Planning Act 2008 - Section 89 and the Infrastructure Planning (Examination Procedure) Rules 2010 - Rule 8

VPI Immingham OCGT Project (the "Project")

Application by VPI Immingham B Ltd (the "Application") for an Order Granting Development Consent for the Project

Development Consent Order Section 42 Consultation Response

Figure 6.3 – Indicative Gas Connection Plan

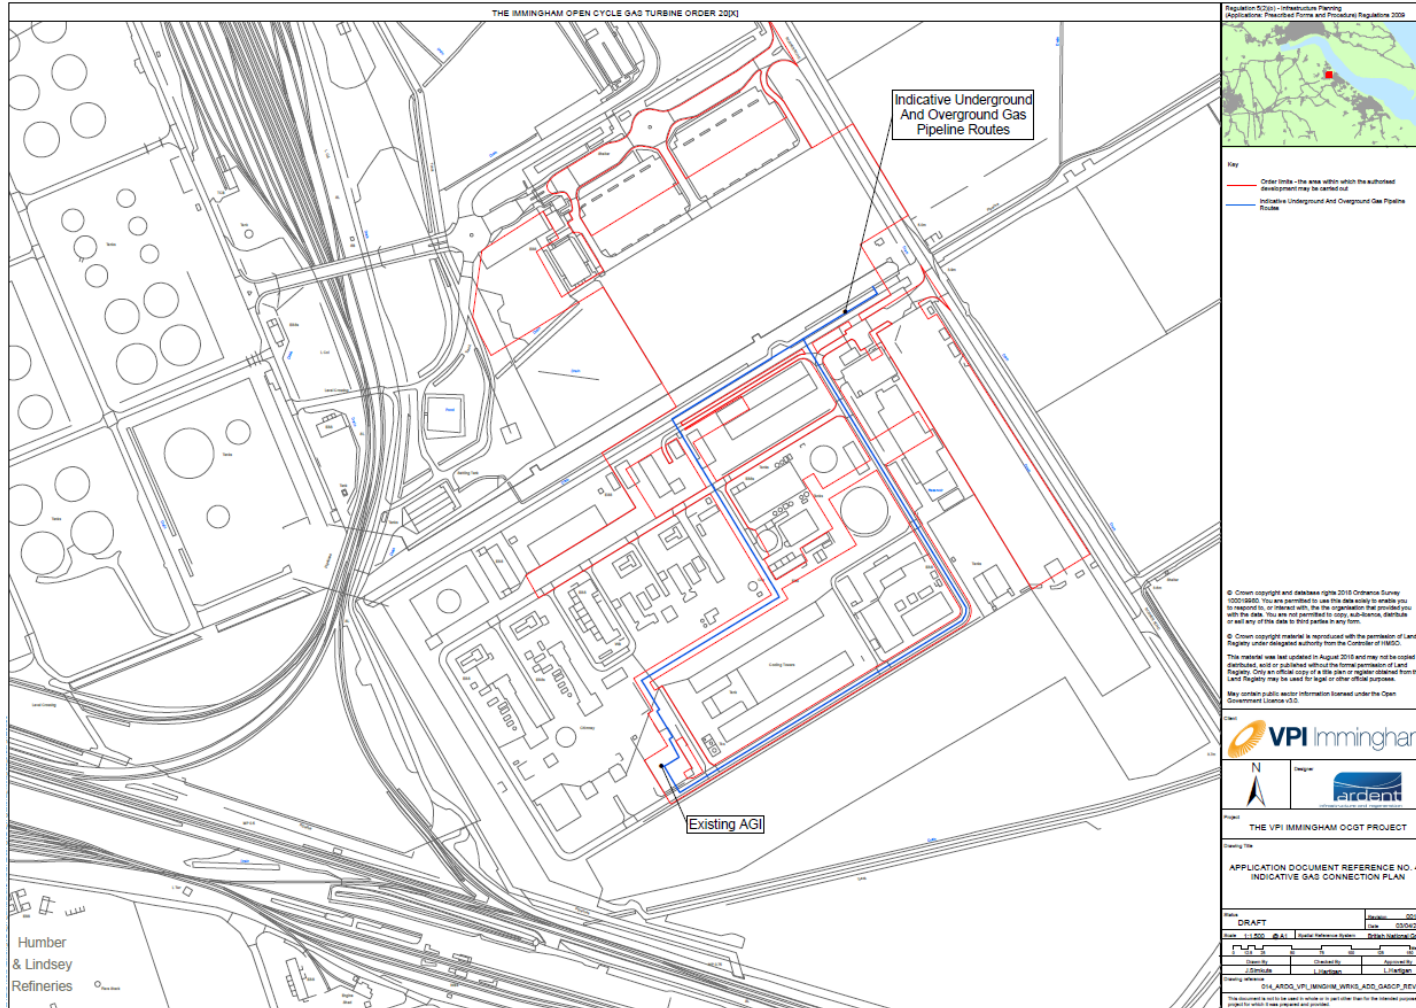
- 4.1 Set out below are a number of questions which APBR believes that it is necessary for the Applicant to answer before it can justify the Project.
- 4.2 For both sections 1 and 2 APBR pipelines (see plans attached), please confirm the proposed construction activity both in terms of method of construction including the proposed quantity of traffic movements, whereabouts and proposed (or potential) excavations in proximity to the said pipelines.

- 4.3 With respect to your new pipelines please confirm whether under or overground, with depths (if applicable) and anticipated interaction with existing infrastructure.

- 4.4 In support of the Applicant's answers in respect of the above, APBR requests full details, with appropriate plans, sections and technical specifications and reports setting out the proposed works in sufficient detail so as to enable APBR to properly understand (a) what is proposed by the Applicant as will affect APBR and (b) the threat to APBR's existing infrastructure by the said proposals.

Drawing Title
**SITE BOUNDARY
 FIGURE 3.1**

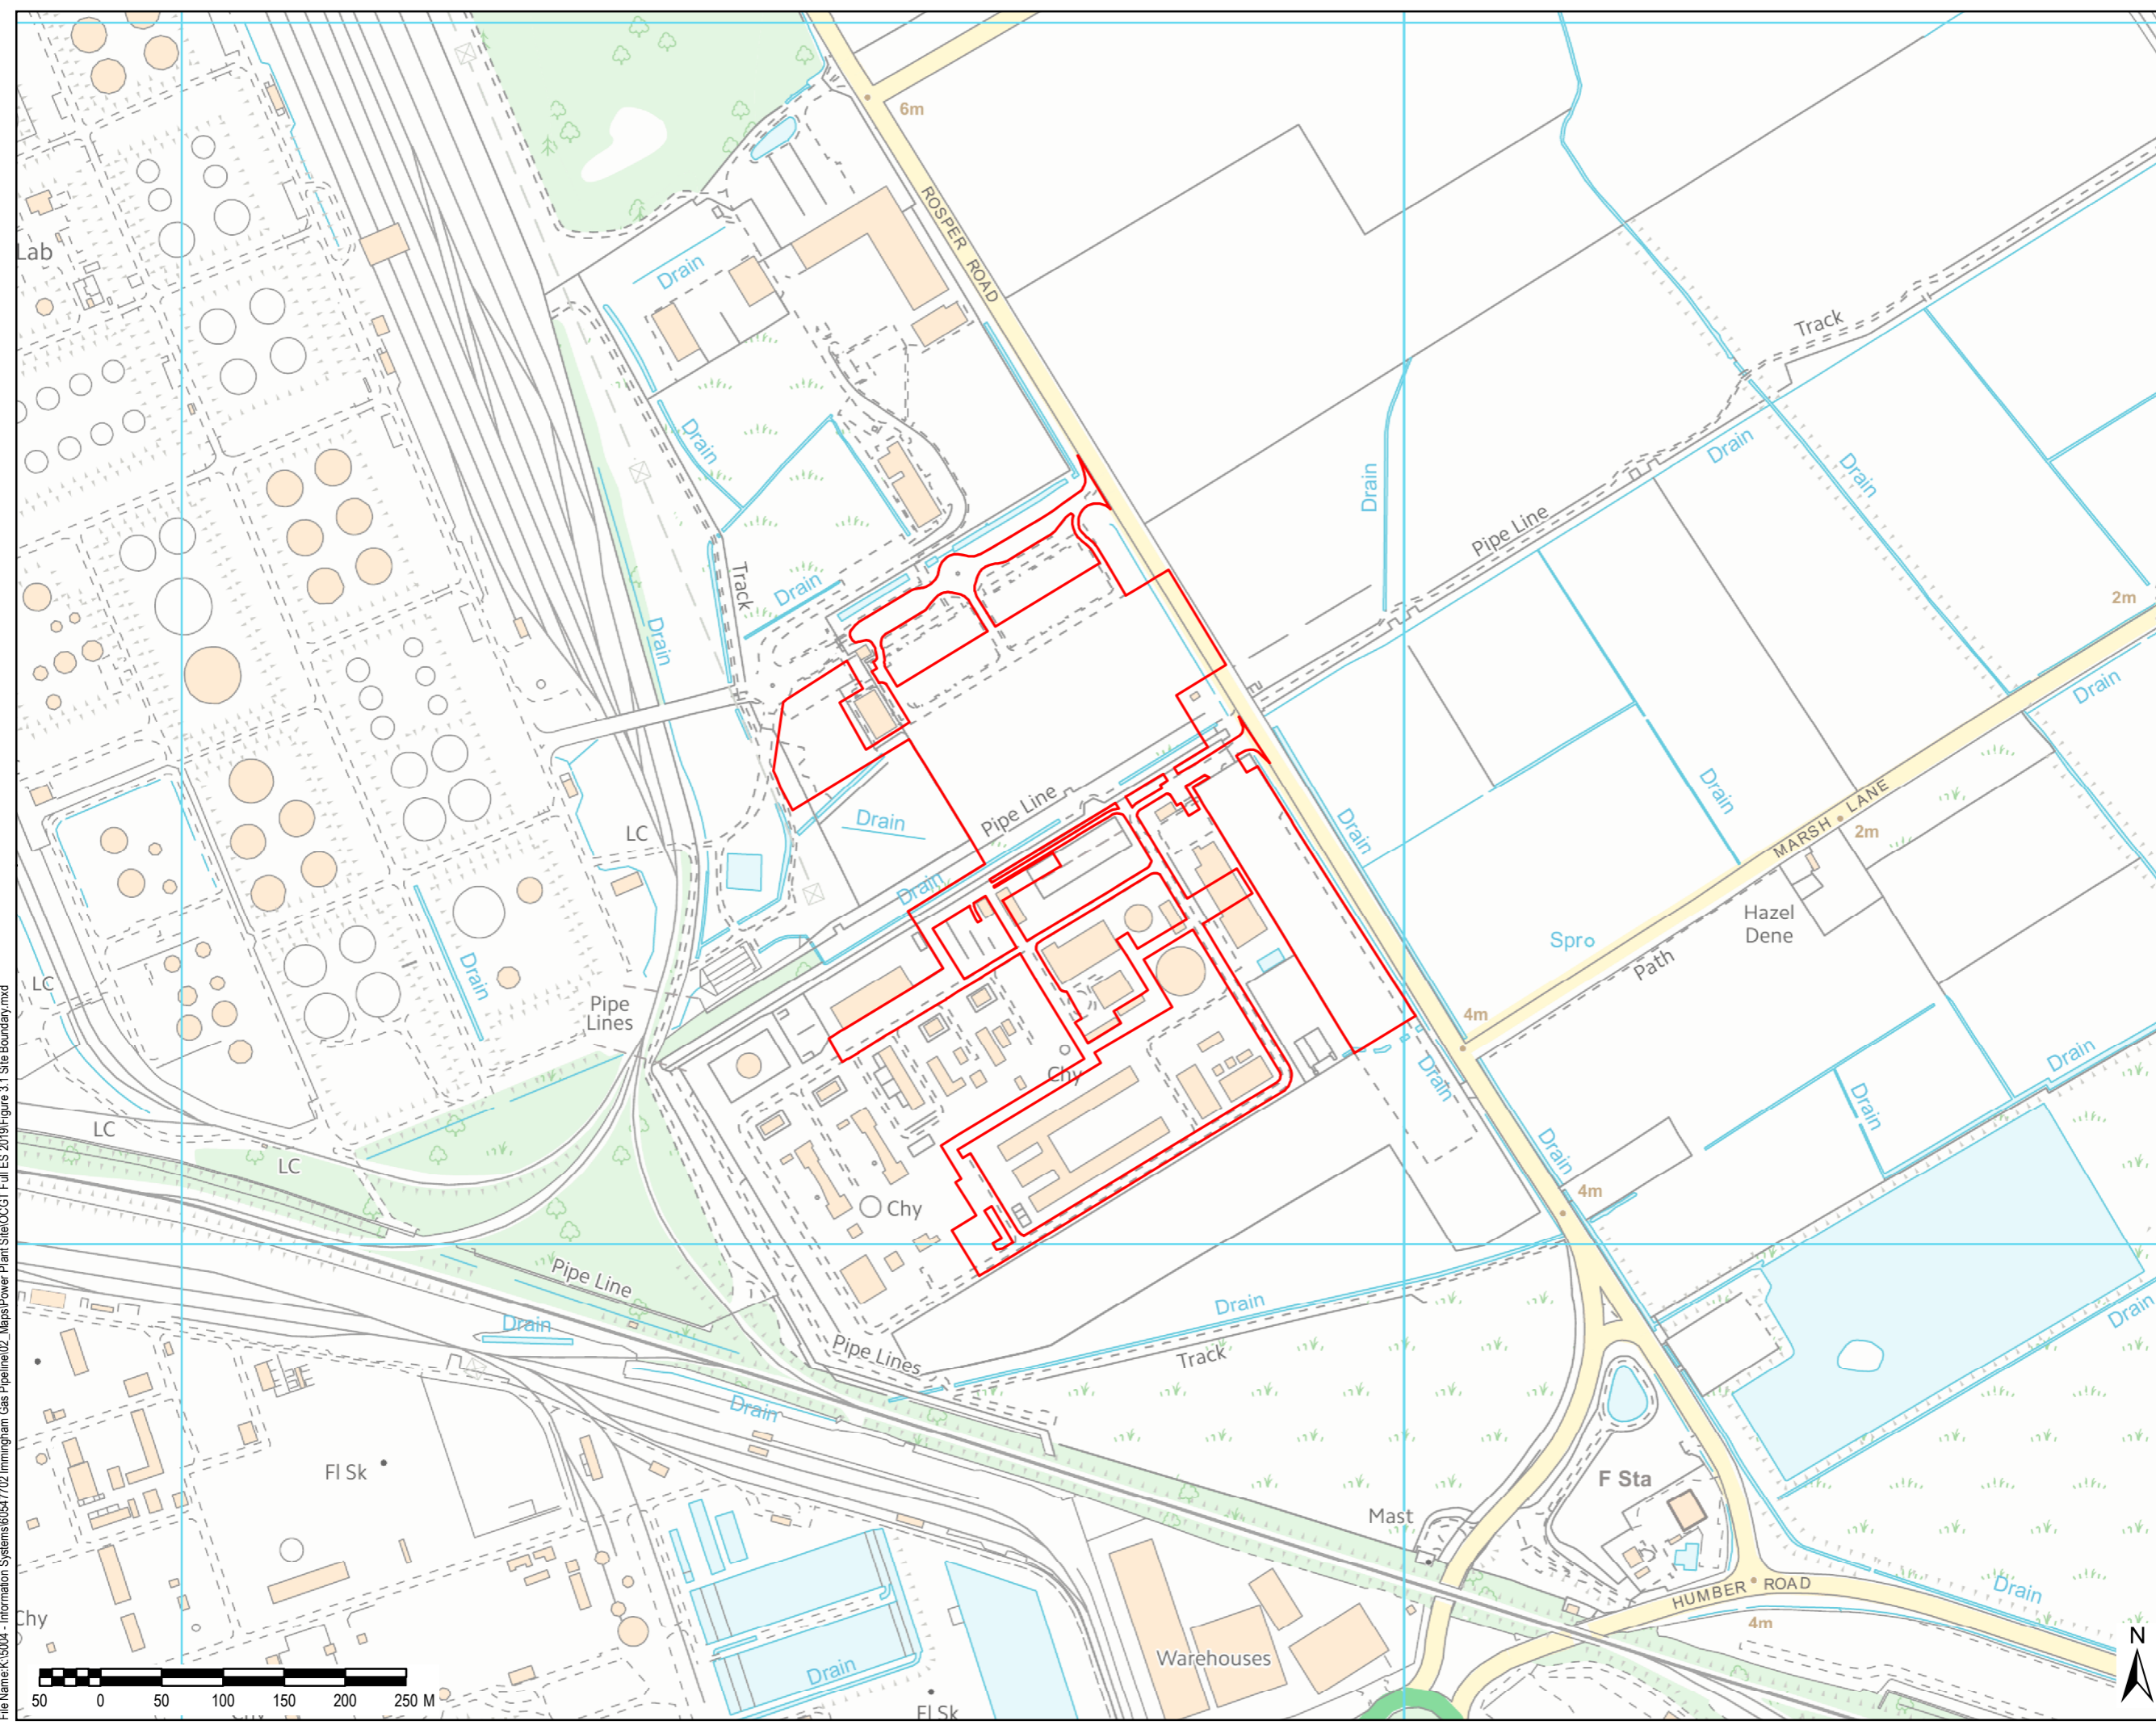
- 2.3 Accordingly, APBR has interests in a number of gas pipelines running through, adjacent to and in the vicinity of the redline boundary shown within the Project consultation documents (see Figure 3.1A to the said documents as an example of the redline).

- Compulsorily acquire the existing gas pipeline currently used for fuelling the existing CHP plant;
- Construct a new gas pipeline in an area (identified in Figure 3.1 to the Consultation documents) in which existing pipelines are located, such pipelines being used by APBR for the purposes of gas supply to both refineries (see paragraph 2.2 hereof);
- Exercise rights to an undisclosed option to take a lease of what is described in the Consultation documents as "the Main OCGT Power Station Site" (although the precise limits both in terms of geographical extent and rights associated with the said lease are entirely unspecified); and
- Acquire rights of access, both temporarily in order to undertake construction works and permanently for future access to pipelines and the power station (and associated infrastructure).

- 3.5 Of even greater concern is that no mention is made of the use of the existing infrastructure by APBR (or any other party), or the proximity of that existing infrastructure to the new infrastructure proposed as part of the Project. Further, the Consultation documents do not, whether adequately or at all, address the use of the areas above ground under which the existing pipelines pass or the proposed use of the land over which the existing pipelines pass.
